28 October 2020

Arrangements for Handling Heritage Applications Direction 2015

**PARKWOOD METHODIST CHURCH, PARKWOOD ROAD, LONGWOOD,
HUDDERSFIELD, HD3 4TT
Application No. 2020/90480**

Drawn: DRH
 Date: Aug 2018
 Scales: 1:100 @ A1
 Drawing No.: 17-023-06
 Rev: A

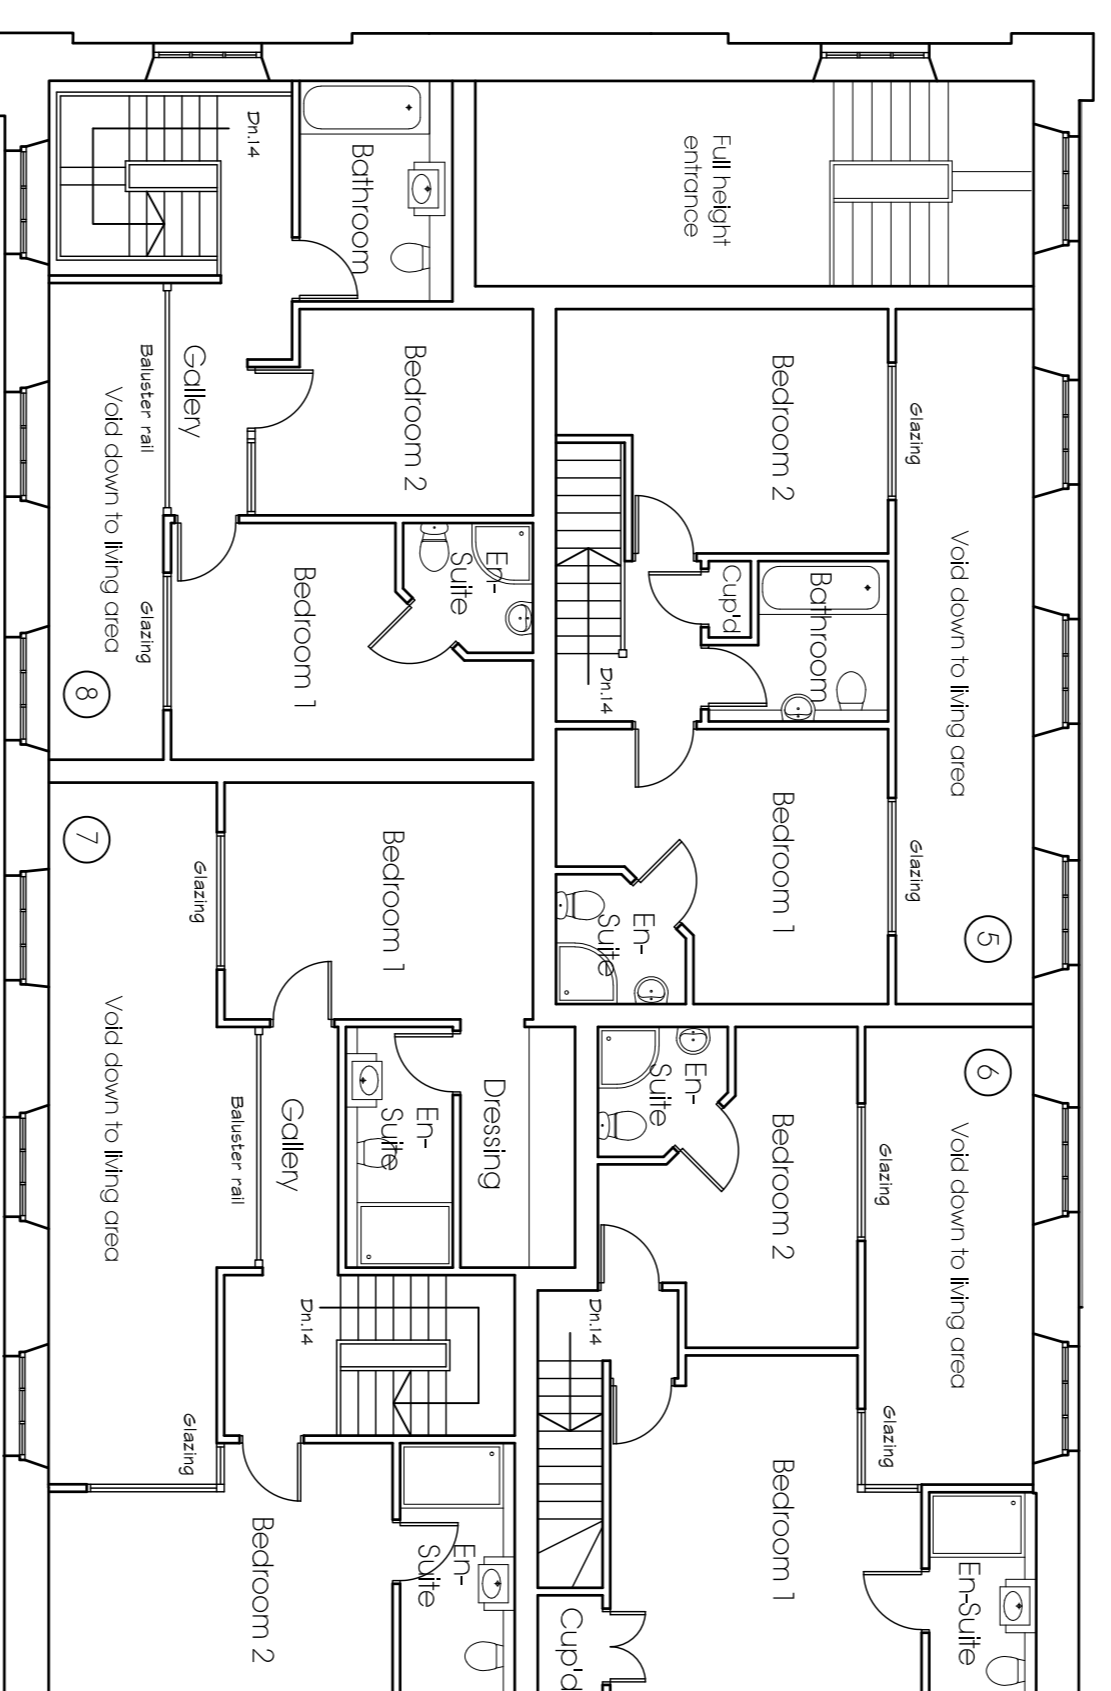
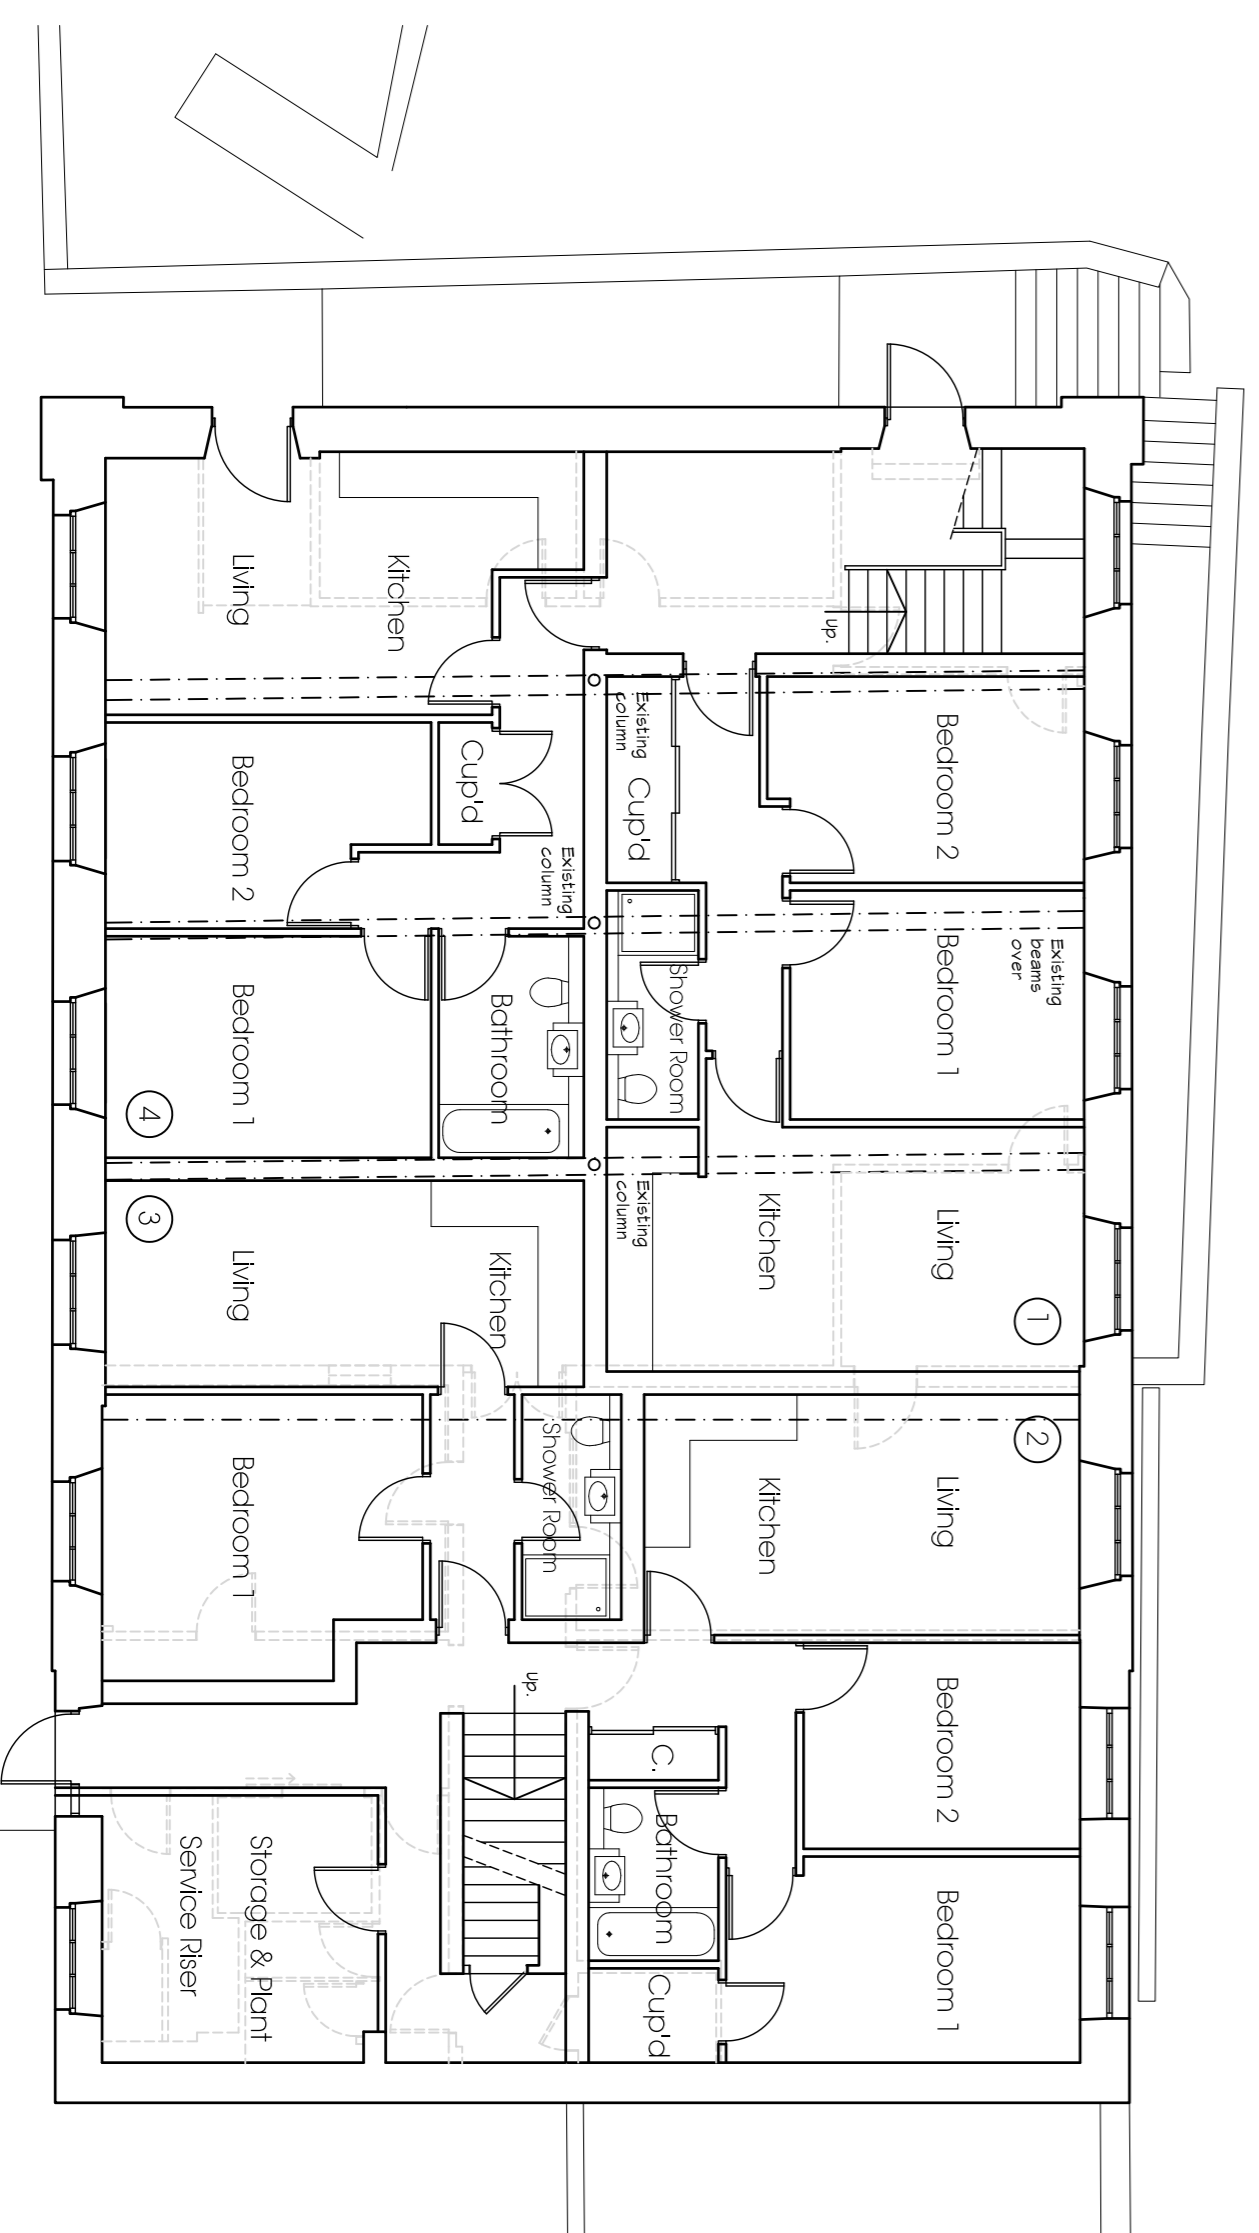
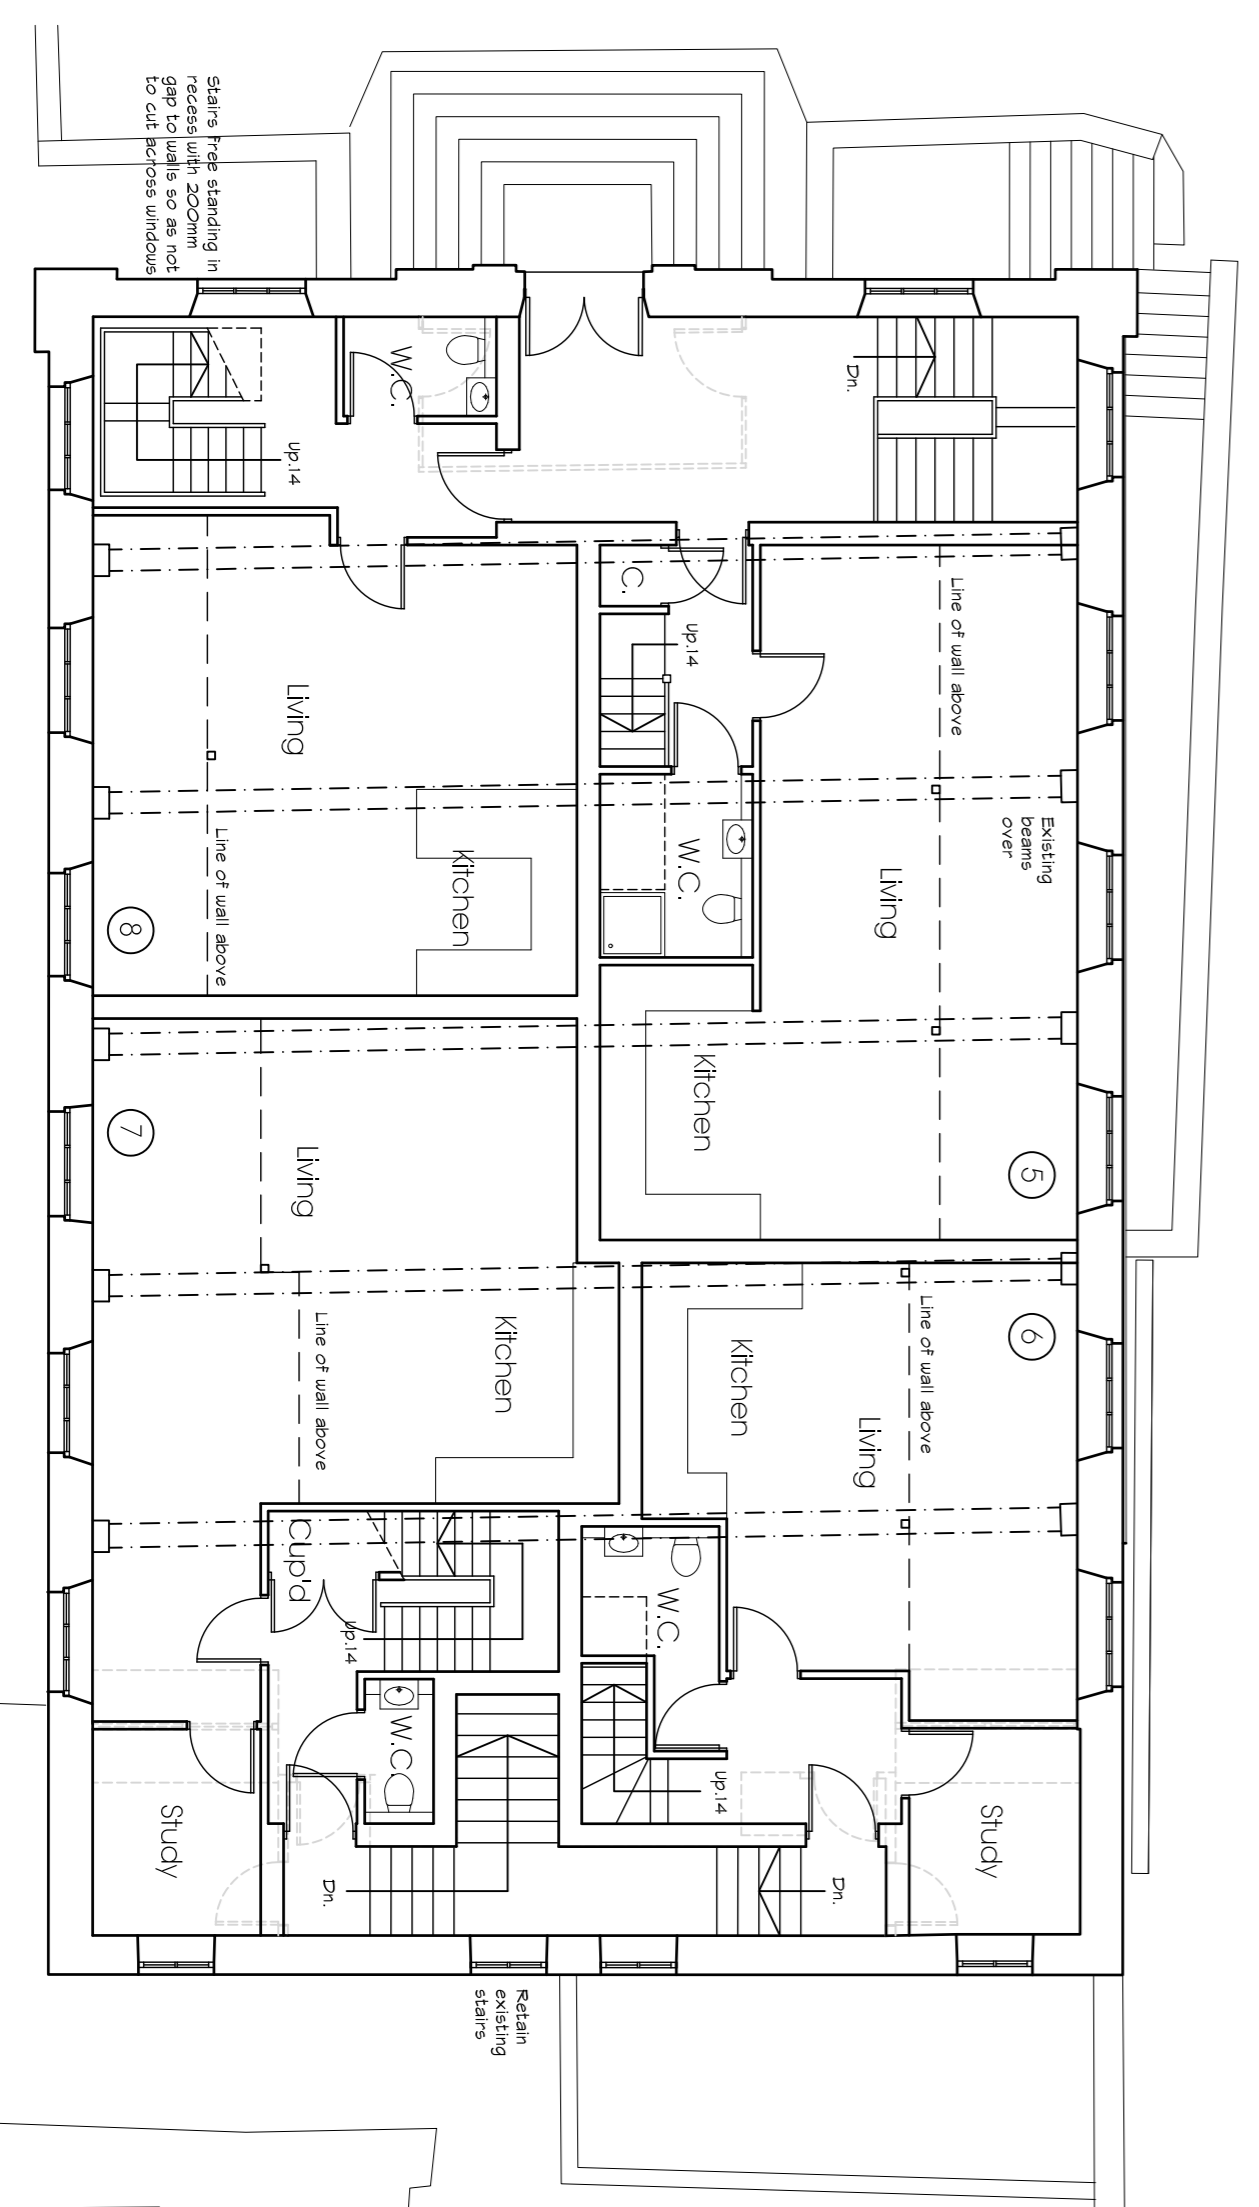
Internally, we acknowledge the retention of some original features, in particular, the staircase connecting the church space with the meeting rooms below and the windows to the north west elevation. We also appreciate that duplex apartments are now proposed within the church space, and that their layout allows the windows to remain uninterrupted as well as a better appreciation of the church space.

Although these amendments are an improvement on the previous scheme, the impact of the proposal on the significance of the church remains considerably high, due to the extent of loss of original fixtures and fittings. This is a concern, considering the degree of intactness of the church interior, which contributes importantly to the reasons to its listing as a building of special interest.

If residential use is justified, then we consider that further mitigation should be offered through additional refinements to the proposal. For instance, a more regular layout would be more consistent with the building's symmetry. The sense of arrival in to the building would be an important consideration here and to that point, further detailing of entrance areas, proposed and existing staircases, duplex spaces, etc., would help ensuring the proposal responds to and is in keeping with the character of the building. We consider that sections and internal elevations would help assessing these points. These should be discussed and agreed in liaison with your conservation advisors, who will also be able to advise you of any necessary conditions.
